Subject: RE: REF 2025/62/91542/E : 39134 - Highmoor Lane, Cleckheaton - Section 38 and 278 Application

They have also not considered the points raised by Highway Safety and HDM in the previous consultation response dated 1st October as follows.

Phoenix 2 Duo (P2-15W with Elite 6x4 chassis)
 Overall Length 11.200m
 Overall Width 2.530m
 Overall Body Height 3.751m
 Min Body Ground Clearance 0.304m
 Track Width 2.500m
 Lock to lock time 4.00s
 Kerb to Kerb Turning Radius 9.500m

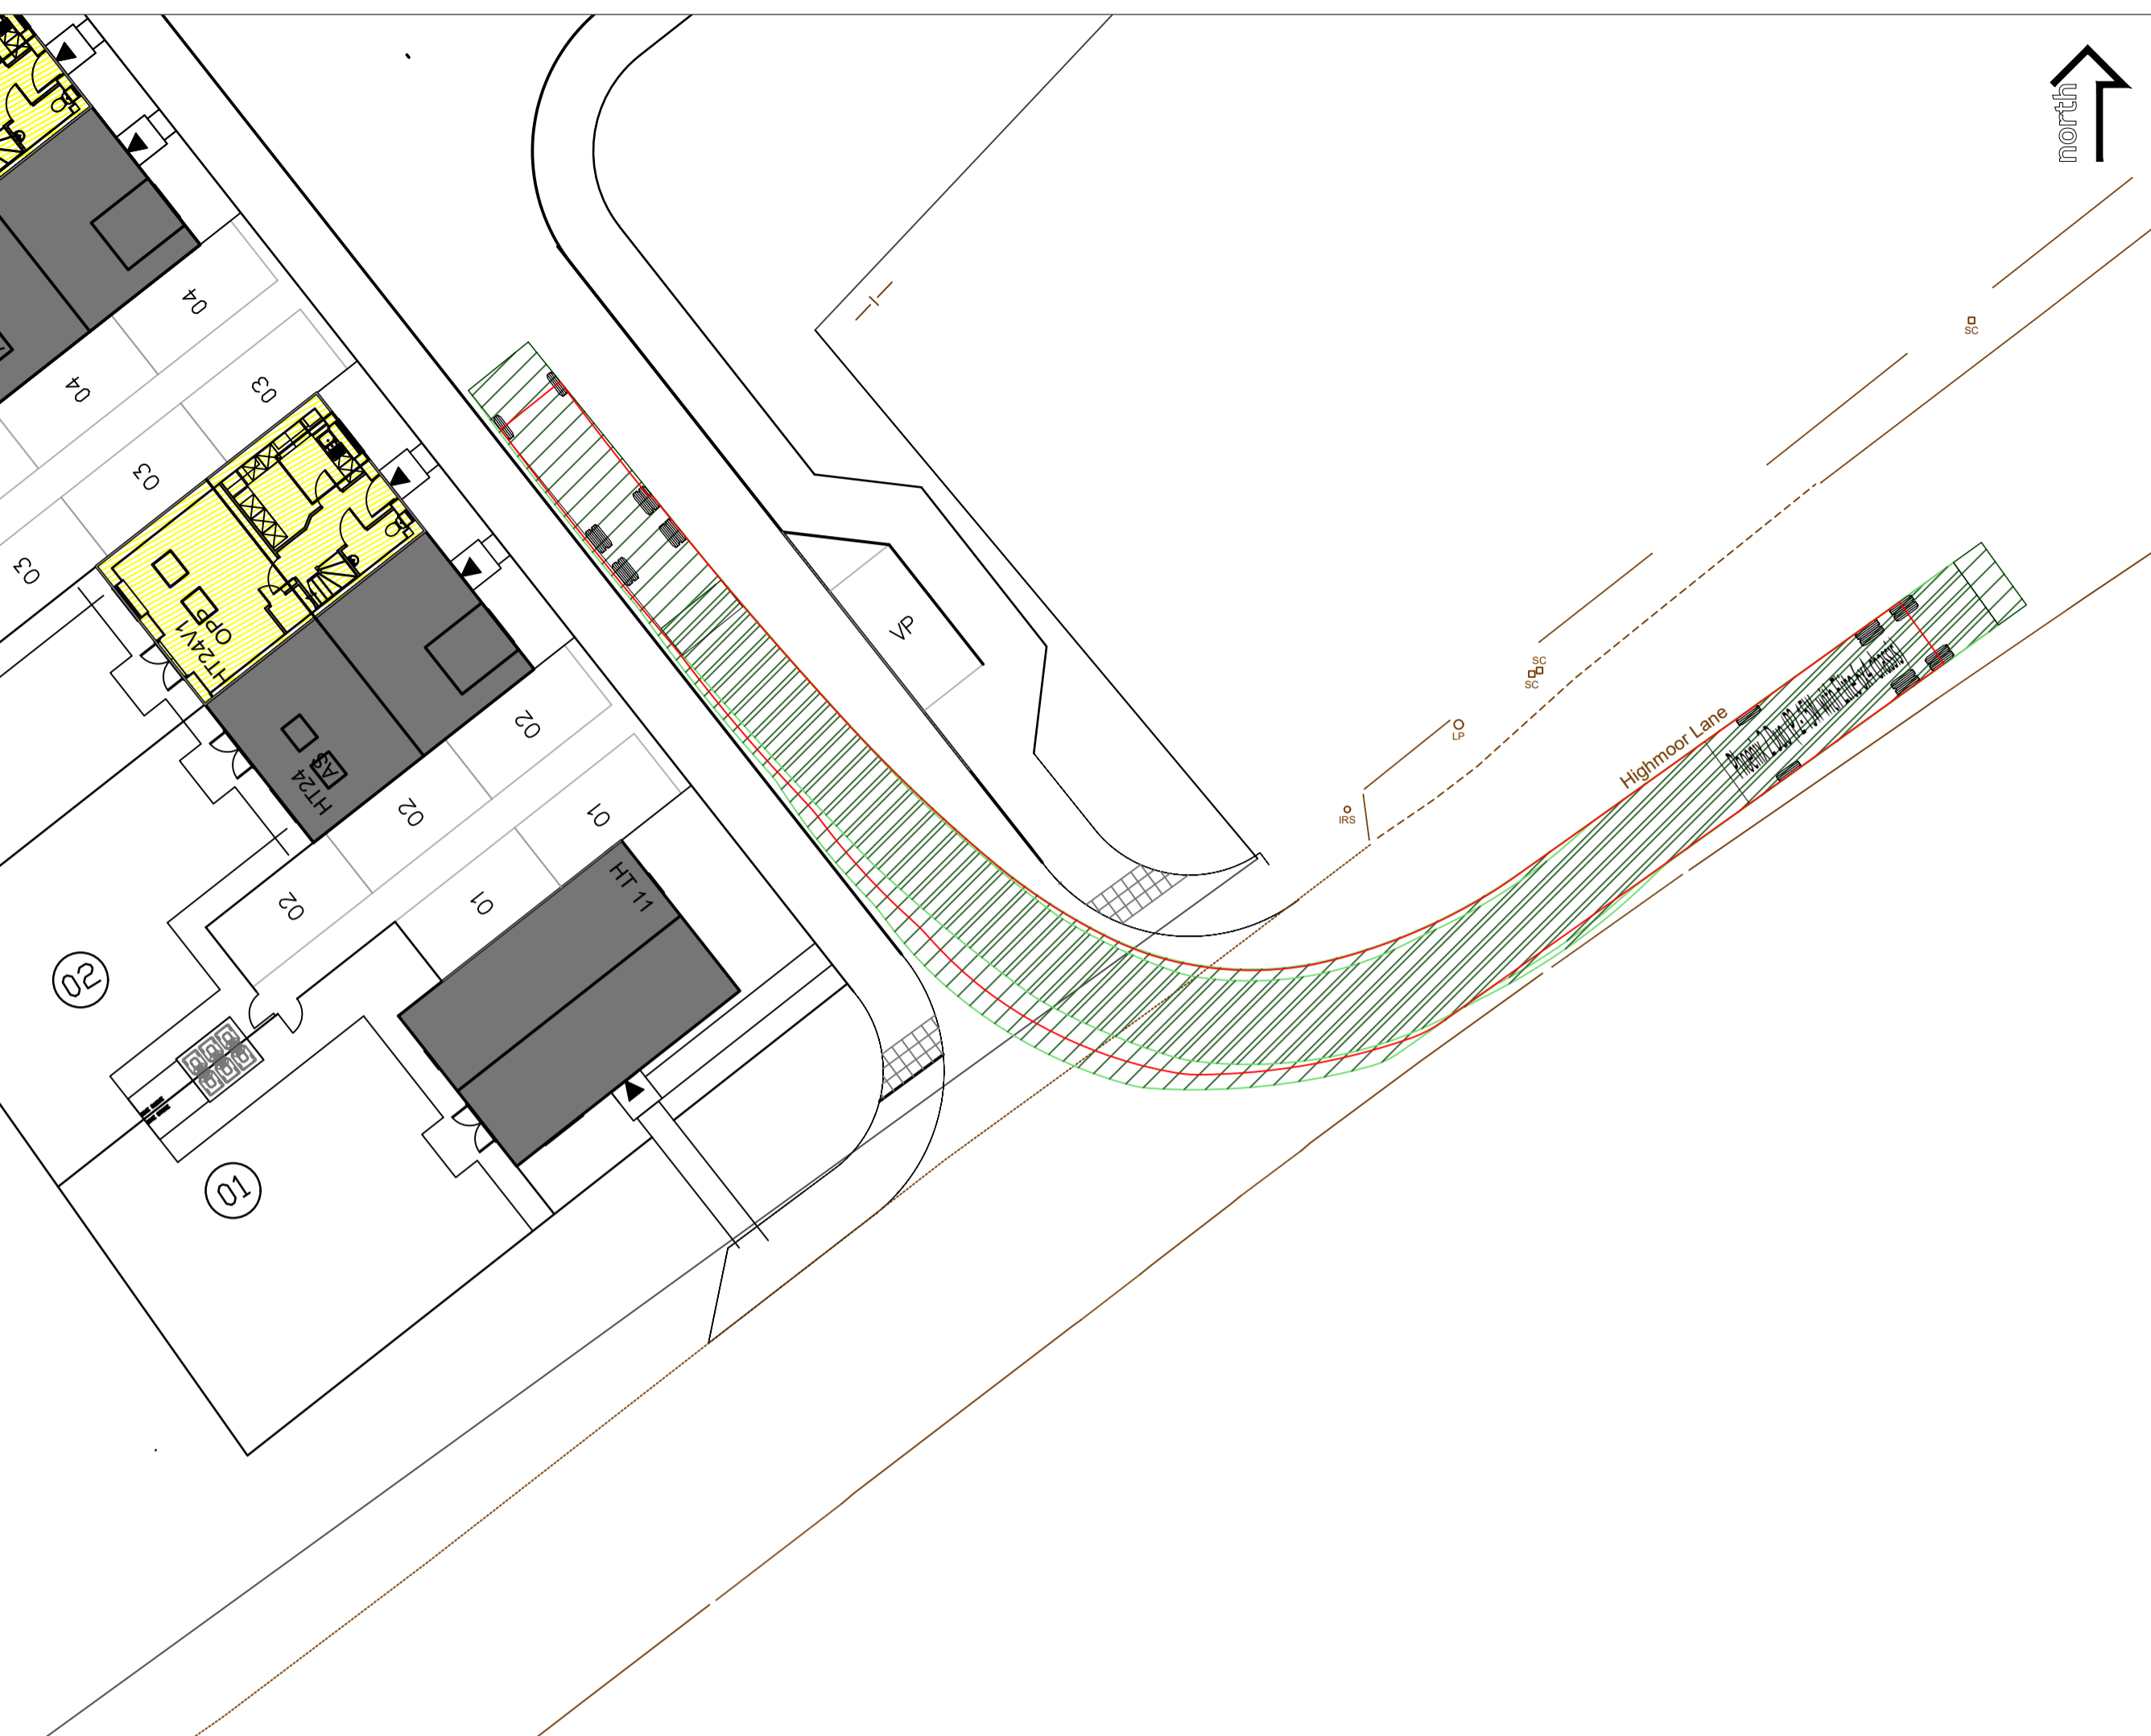
5, Swept paths should be provided which demonstrate that an 11.85m refuse vehicle can enter and exit the site from Highmoor Lane and turn within the site. All schemes must incorporate reasonable tolerances and safety margins. A good starting point is to allow 0.5m clearance to kerbing or vertical obstructions on
